Our ref: NO/2013/105444/02-L01
Your ref: 3/2013/0610
Date: 18 October 2013

**PROPOSED SLURRY LAGOON (RETROSPECTIVE)
WITHGILL FARM, WIGHILL FOLD, WITHGILL, CLITHEROE**

Avalon Chartered Town Planning	
Town Planning - Architectural Design - Building Regulations - Surveying	
Phone: 01282 334834 Fax: 01282 451666 E-mail: info@avalonrpi.co.uk 2 Reading Business Centre, Redman Road, Bursley, Lancashire, BB10 2TV	
PROPOSED SITE PLAN

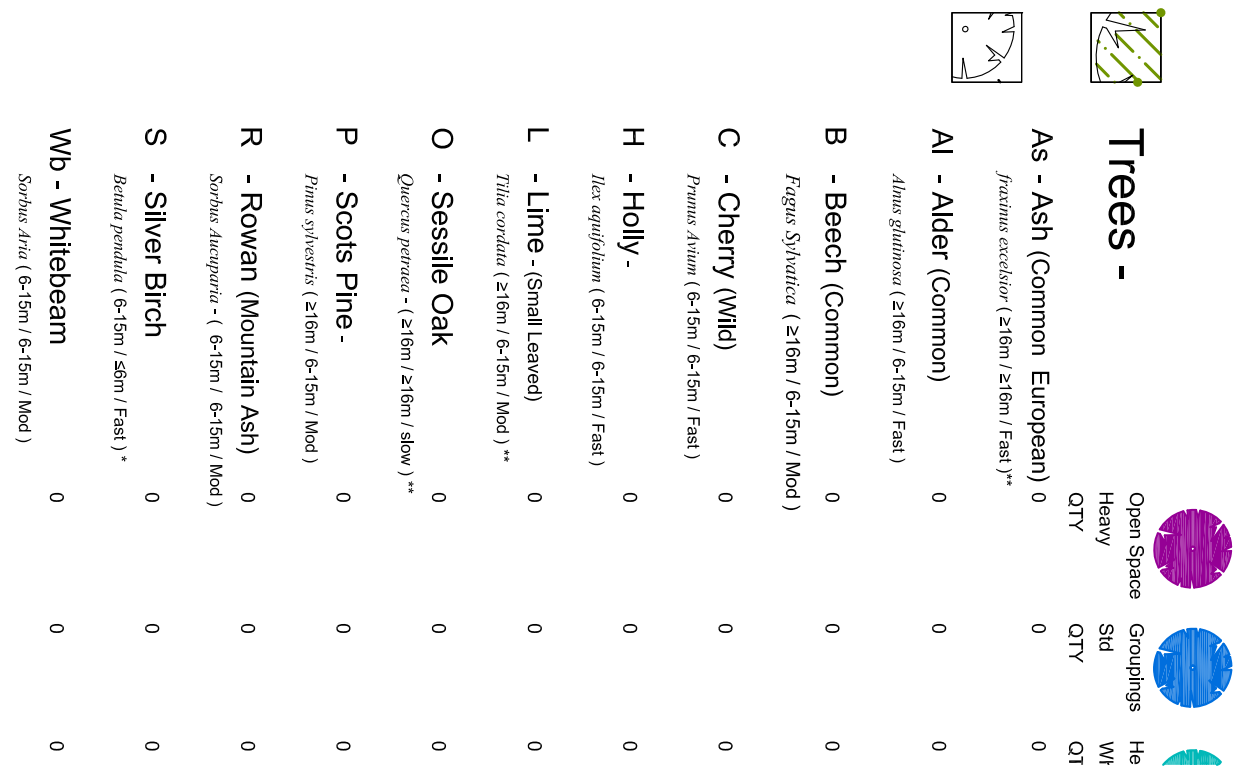
To ensure that the development does not result in any loss of habitat, it has been proposed to locate a new pond between the two slurry lagoons. It would appear that a pond in this location could prejudice access to the lagoon bunds for maintenance/repair and if the biodiversity value of a pond in this location may be limited.

Based on the Ordnance Survey map of the site, we understand that there is another pond approximately 100 metres to the west of the lagoons, at grid reference SD 70666 41368. Rather than create a new pond in an inappropriate location, it would be preferable to ensure that an existing pond is subject to biodiversity improvement and enhancement works such that the loss of habitat associated with the lagoon is compensated for. To this end, we would recommend that rather than conditioning a new pond as part of any subsequent approval, a scheme for the enhancement and improvement of the pond at grid reference SD 70666 41368 is submitted, approved and implanted instead:-

CONDITION Within 2 months of the date of this permission, details of a scheme for the ecological improvement/enhancement of the existing pond at grid reference SD 70666 41368 the west of the slurry lagoon hereby permitted shall be submitted to and approved in writing by the Local Planning Authority. The approved scheme shall be fully implemented to a timescale that has also first been agreed in writing by the Local Planning Authority
